Please ask for: Ms Iqraa Malik
Email: iqraa.malik@terraquest.co.uk
Telephone: 01212341390
Our Ref: FP/133/21/HH
Your Ref:
Date: 16th June 2021

Application for Planning Permission for Works or Extension to a Dwelling

Development: Erection of single storey front, side and rear extensions and detached annexe
Location: 33 Poulner Close Felpham PO22 8HN

FLOOR PLAN

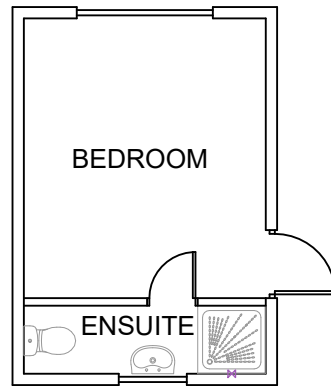
Room Labels

Please add room labels to the detached annexe floor plan
